TfNSW reference: REN 25/00054/003

Your reference: SSD 29491142

SSD-29491142, Coborra Solar Farm and BESS, located approx. 20km south west of Dunedoo and 55km east of Dubbo in the Central West Orana (CWO) Renewable Energy Zone (REZ). Response to Environmental Impact Statement

Strategic Design – Golden Highway Access

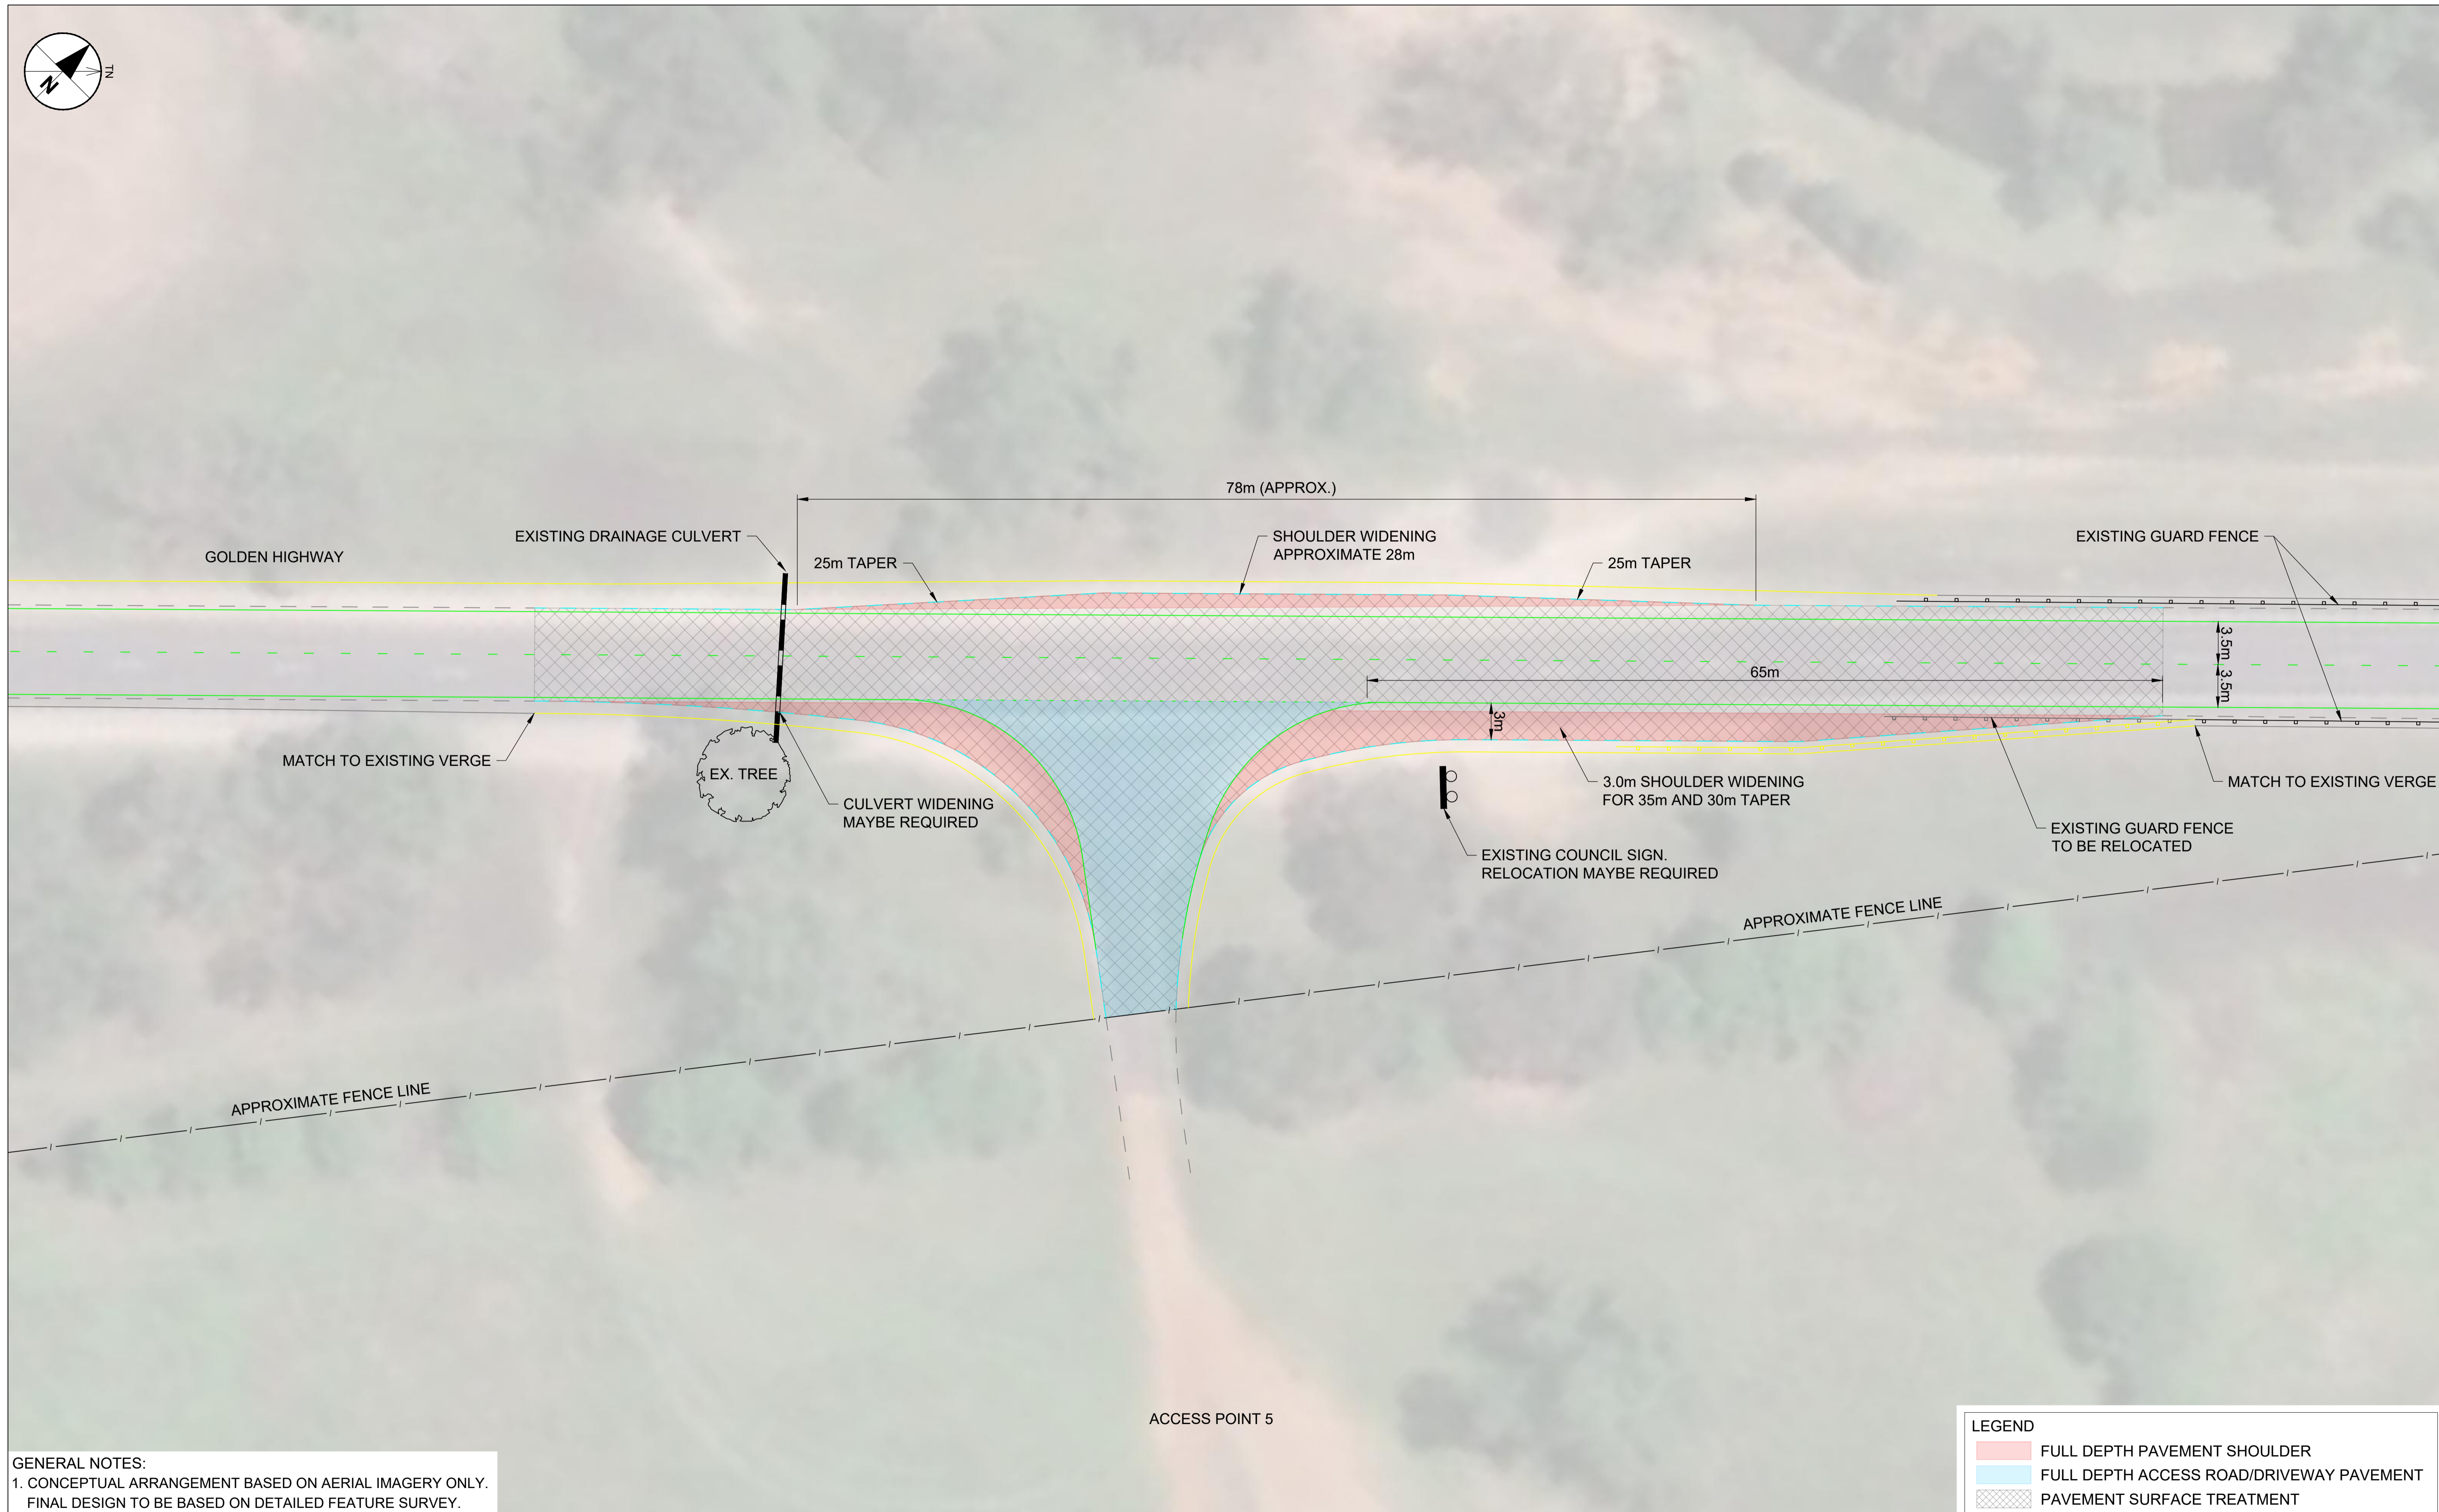
TfNSW has reviewed strategic design and requires the following matters to be addressed to ensure full compliance with applicable drainage and safety design standards.

- a) Plan package is to be dimensioned.
- b) Minimal line-marking and delineation has been shown. Insufficient information has been provided to assess proposed widening works, crossfall etc. Documentation is to be revised with the required delineation details as per TfNSW technical standards.

- c) Include details of the guard rails.
- d) All required signage, including stop signage, is to be demonstrated on the plans.
- e) Standard road drainage details covering surface runoff management, subsoil drainage, and culvert configurations.

- f) Concurrent turn movements not shown for design vehicles. Swept path analysis for the concurrent turn movements is to be provided for the design of heavy vehicles.

- g) The proposed culvert is to be widened, and the drawing package must be updated to accurately reflect relevant design details. This should include:

- i. An invert level profile
 - ii. A detailed culvert analysis, incorporating blockage factor assessment for pipes exceeding 600 mm in diameter
 - iii. Riprap design at both the upstream and downstream ends.

Note - These elements are to be developed in accordance with the Austroads Guide to Road Design, specifically: Part 5A, Section 3.5 – Hydraulic Design and Invert Levels; Part 5B, Sections 4.4 and 6.3 – Culvert Design and Energy Dissipation; Part 6, Section 5.3 – Roadside Safety and Clear Zones.
